Document No: LE03-01-SY23-127-
CBB-CoE-Fire-Tank-
Configuration.docx

**RE: State Significant Development Application (SSDA-69627466) - 3 Edison Lane,
Belmore - Fire Tank Configuration**

LOWER LEVEL VIEW - APPROVED FIRE TANKS

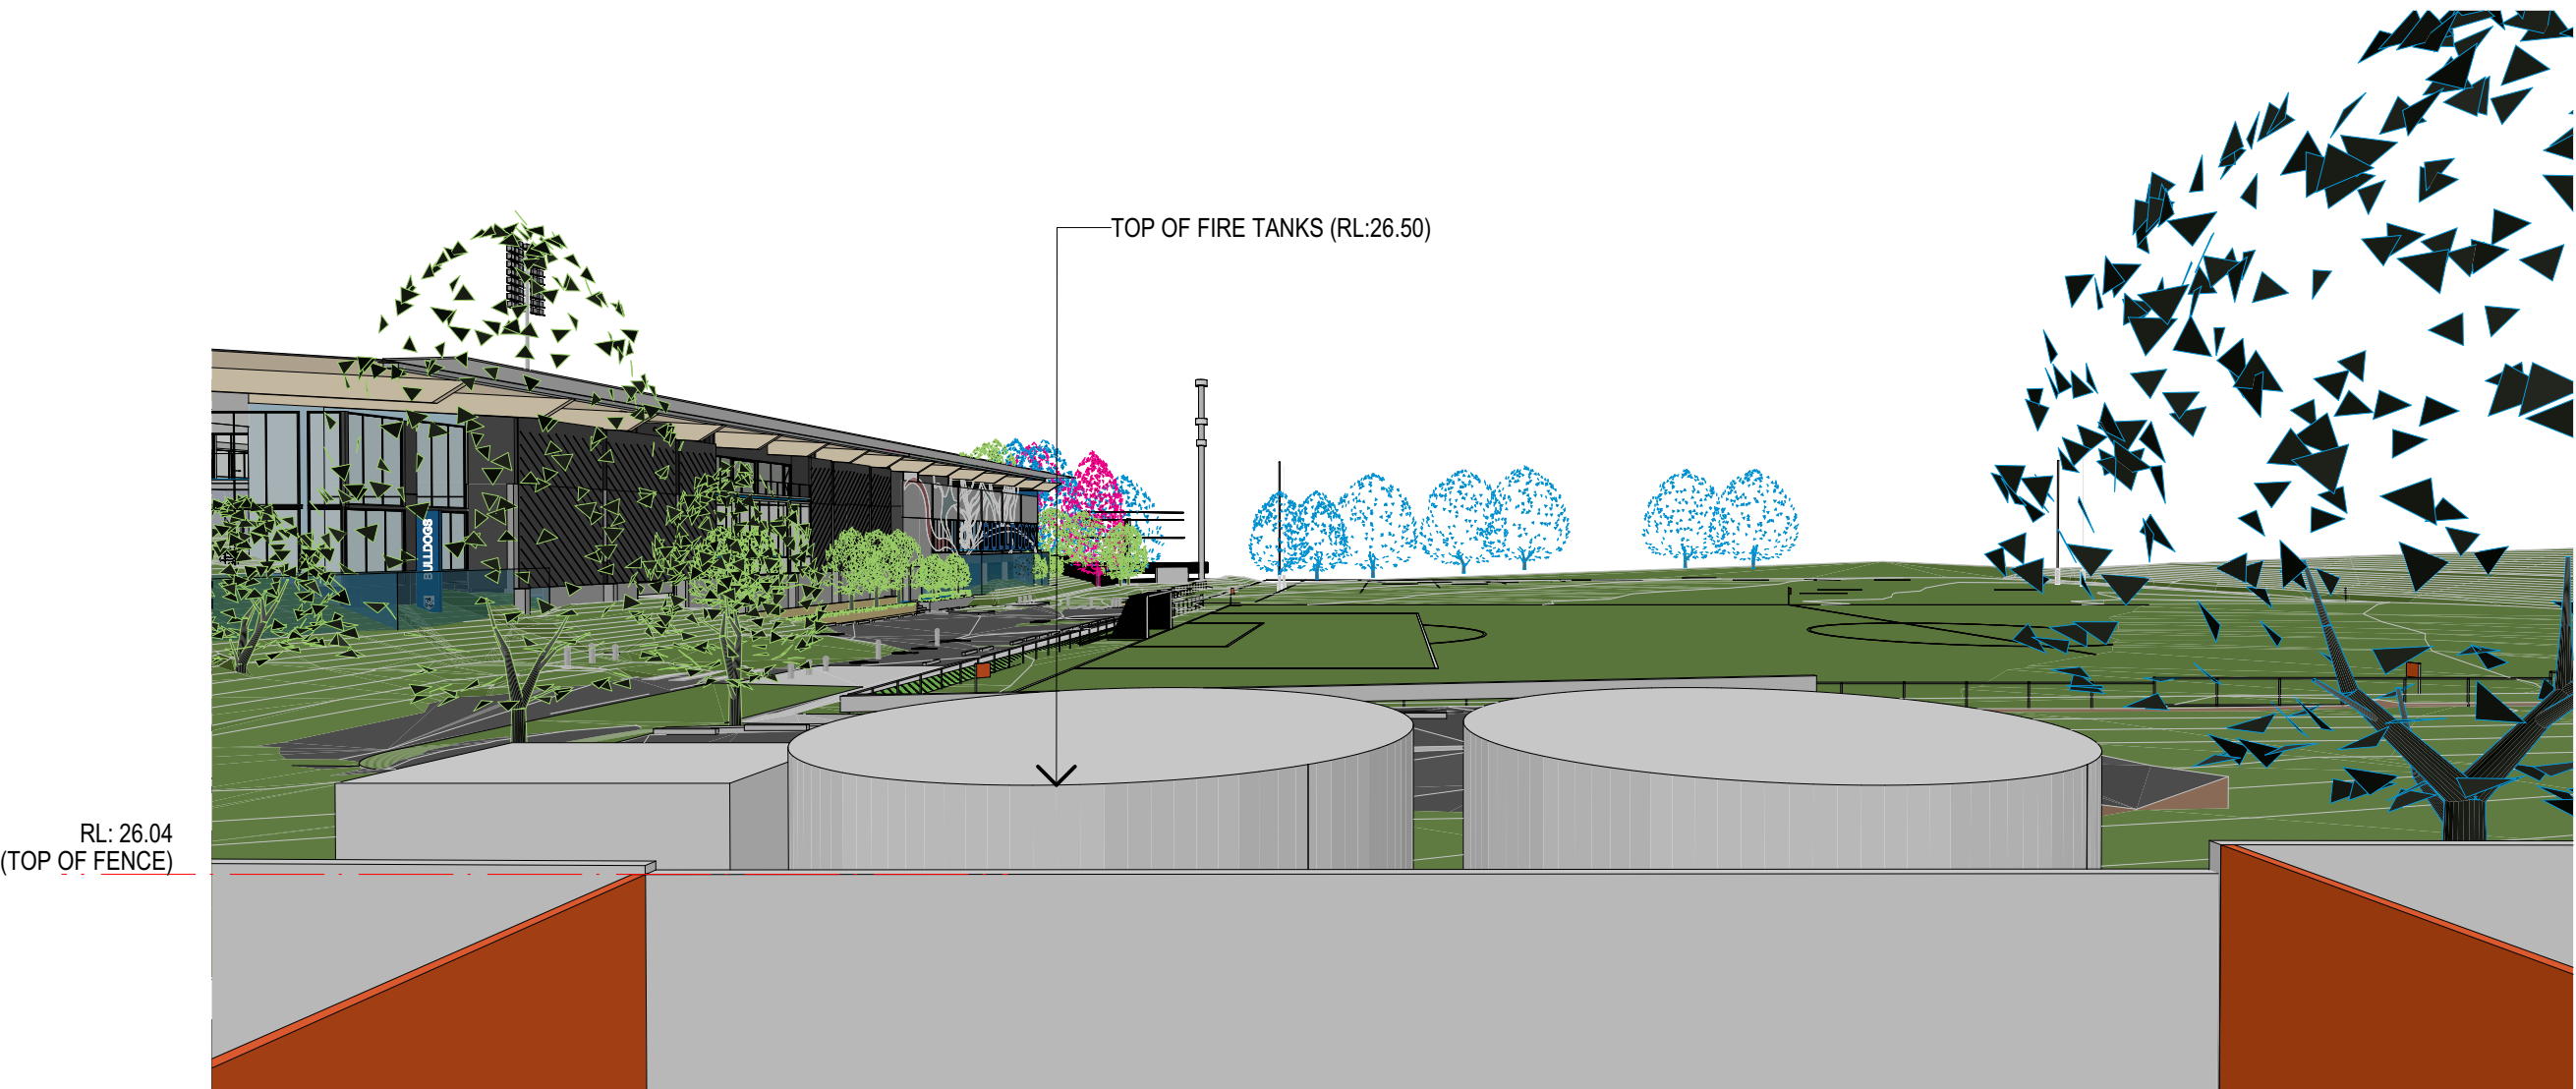
This letter is prepared by Sky Engineering & Project Management Pty Ltd in response to the justification to the alternative configuration of the fire tank which differs from the original SSDA application. The original SSDA submission illustrates the proposed fire tank as being a circular tank, see figure below.

After the SSDA submission the tank had been reconfigured to rectangular tanks, during detail design.

The change in tank shape configuration is based on the following:

To conclude, based on existing utilities constraints and additional Council's drainage easement, the design of the fire tank has been evaluated appropriately to suit services authority and Council's requirements. Overall, the design intention is the same as the original submitted SSDA application.

DESCRIPTION
50KL E.C FIRE HYDRANT TANK 13.6 X 2.0 X 2.5H + DIV
DRAWING NUMBER
004246_TANK ASSEMBLY

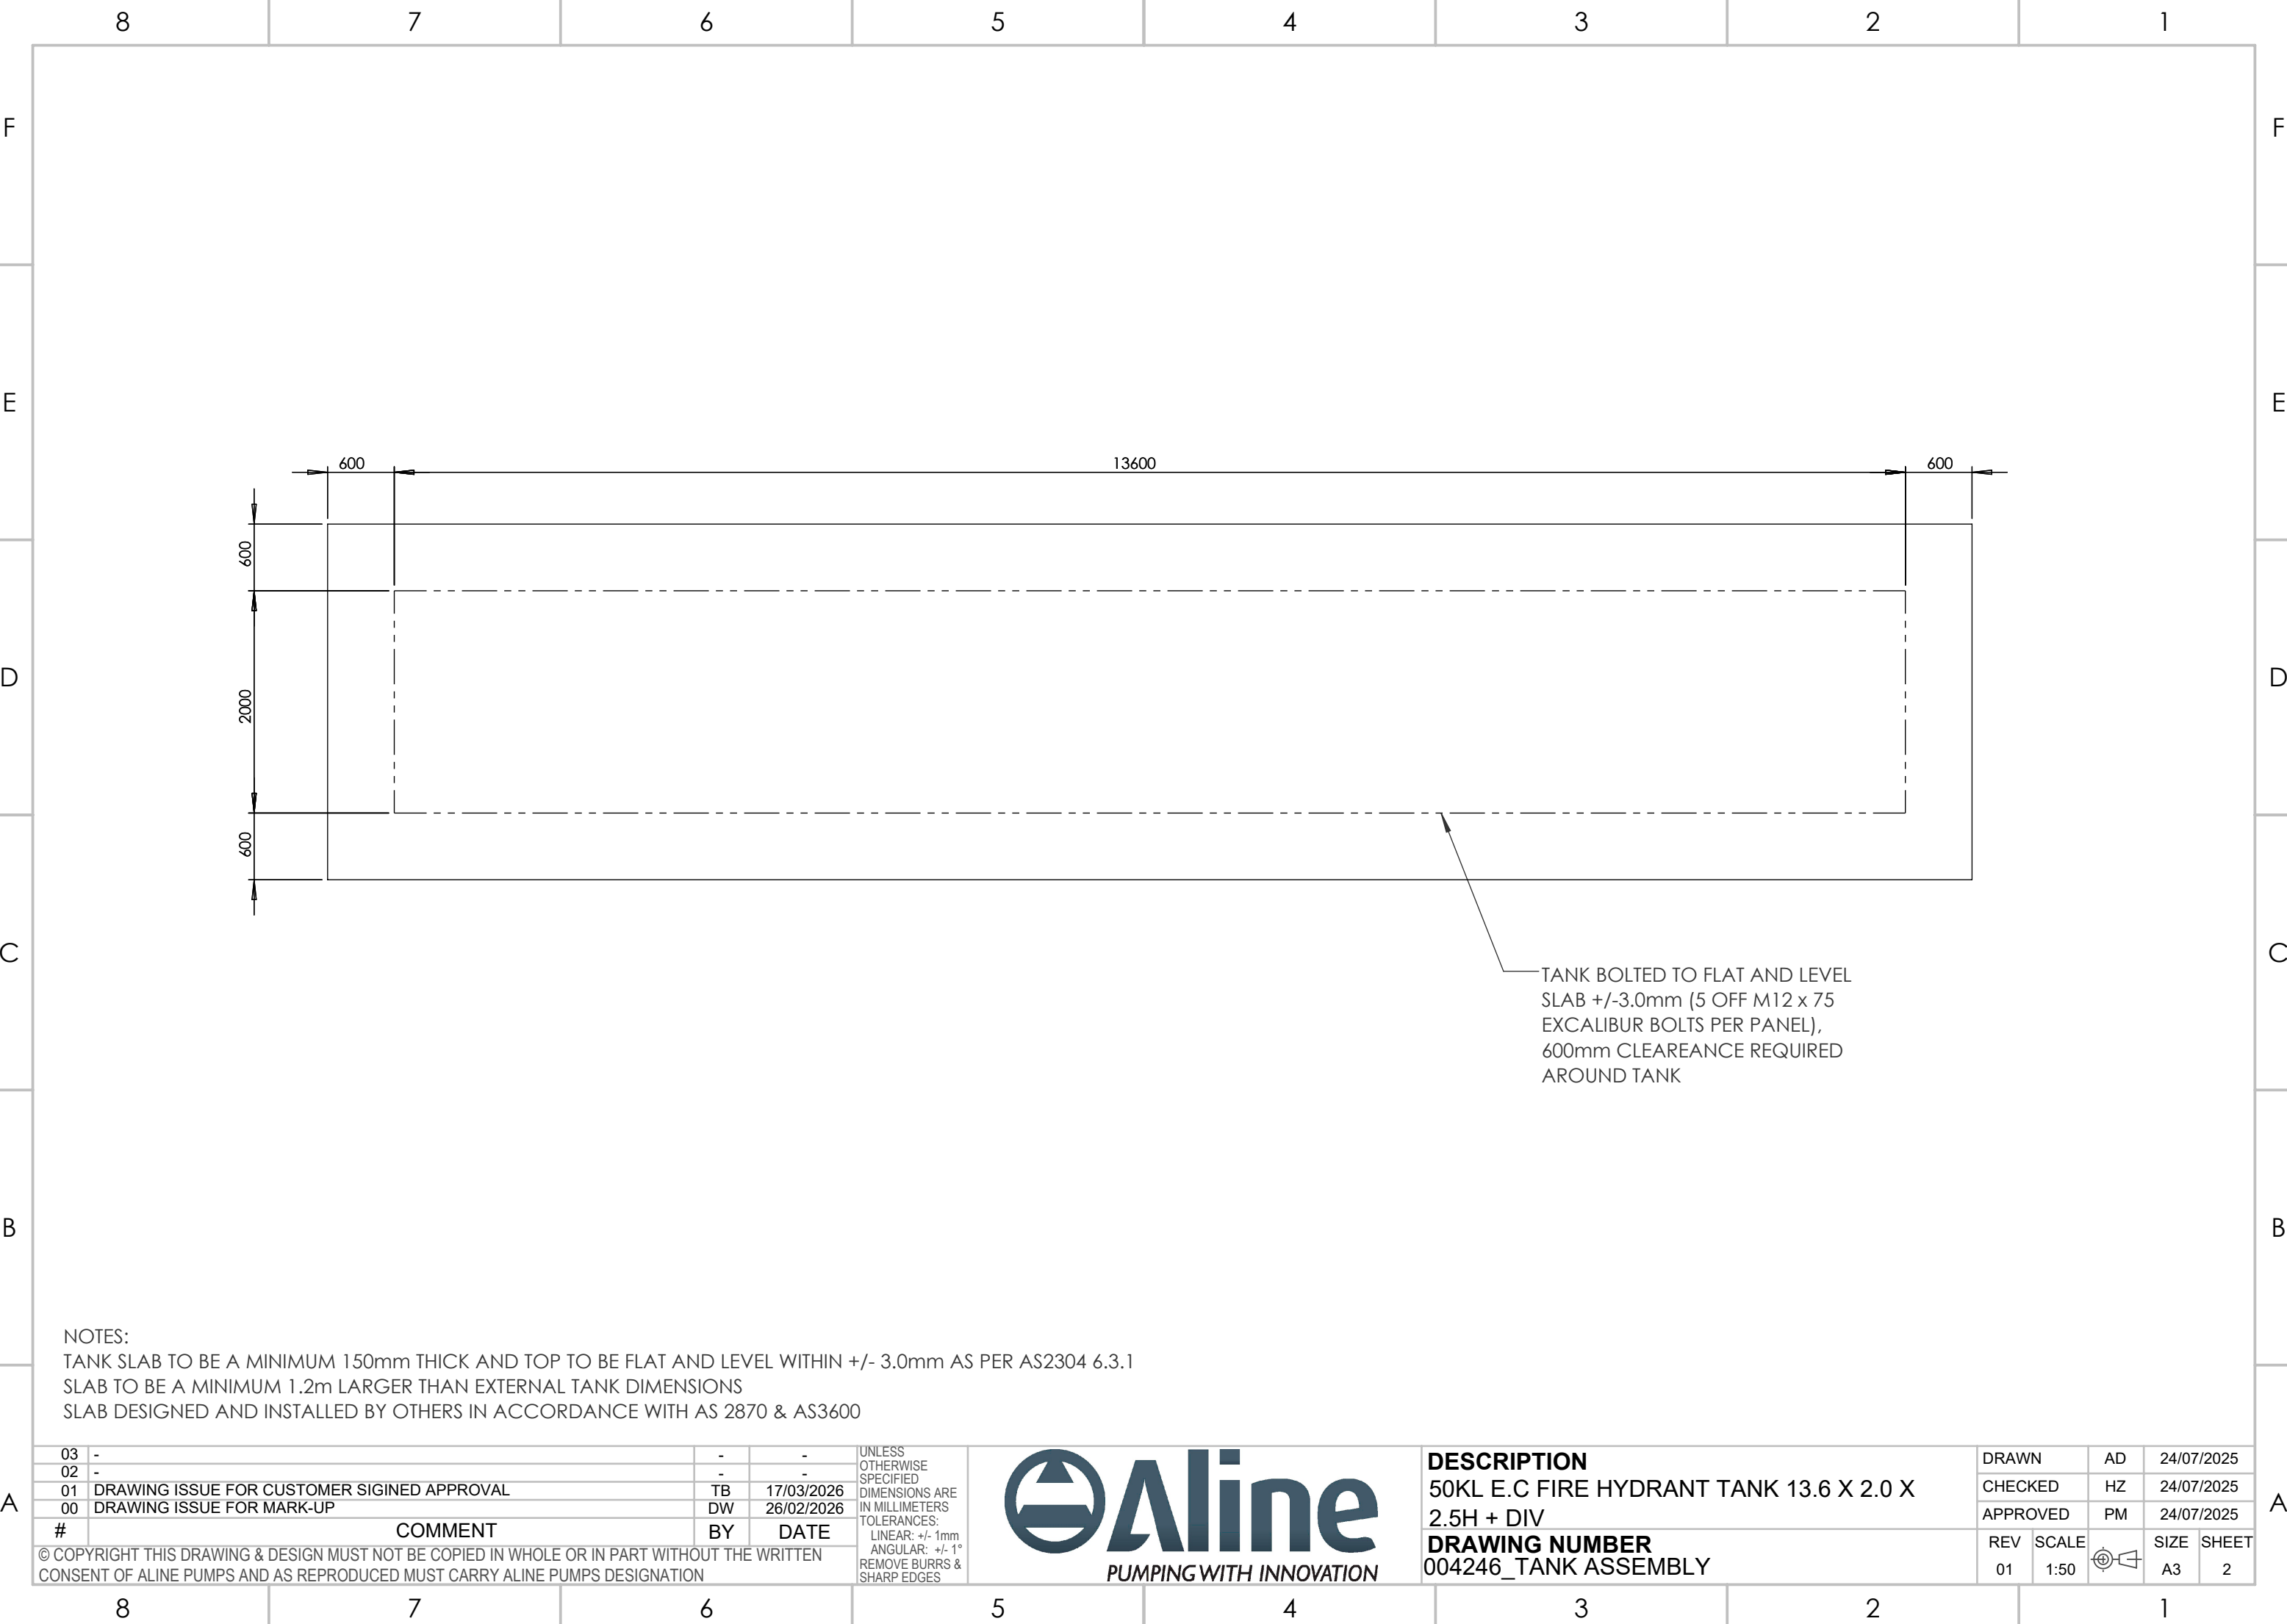
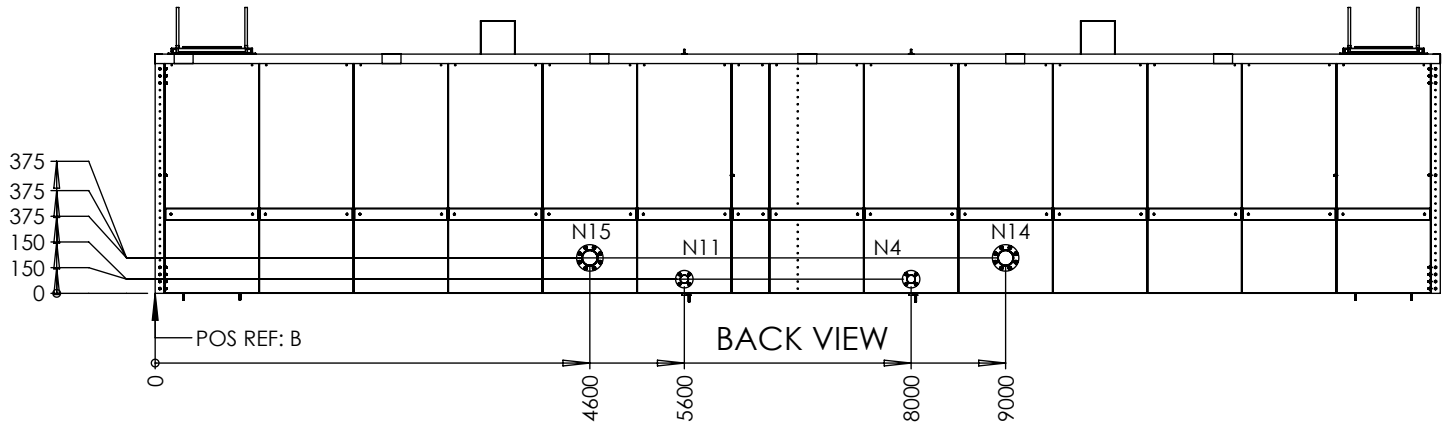
Upon discovering an existing stormwater drainage line adjacent the proposed fire tanks, Council noted an 3m wide drainage easement is applied to the existing stormwater drainage. The drainage easement is not registered as part of the section 88B Instrument, thus impacting the configuration during detail design. The 3m drainage easement requires no footprint encroachment from the fire tank, to achieve compliance a rectangular shape fire tank is proposed, see **Figure 3**.
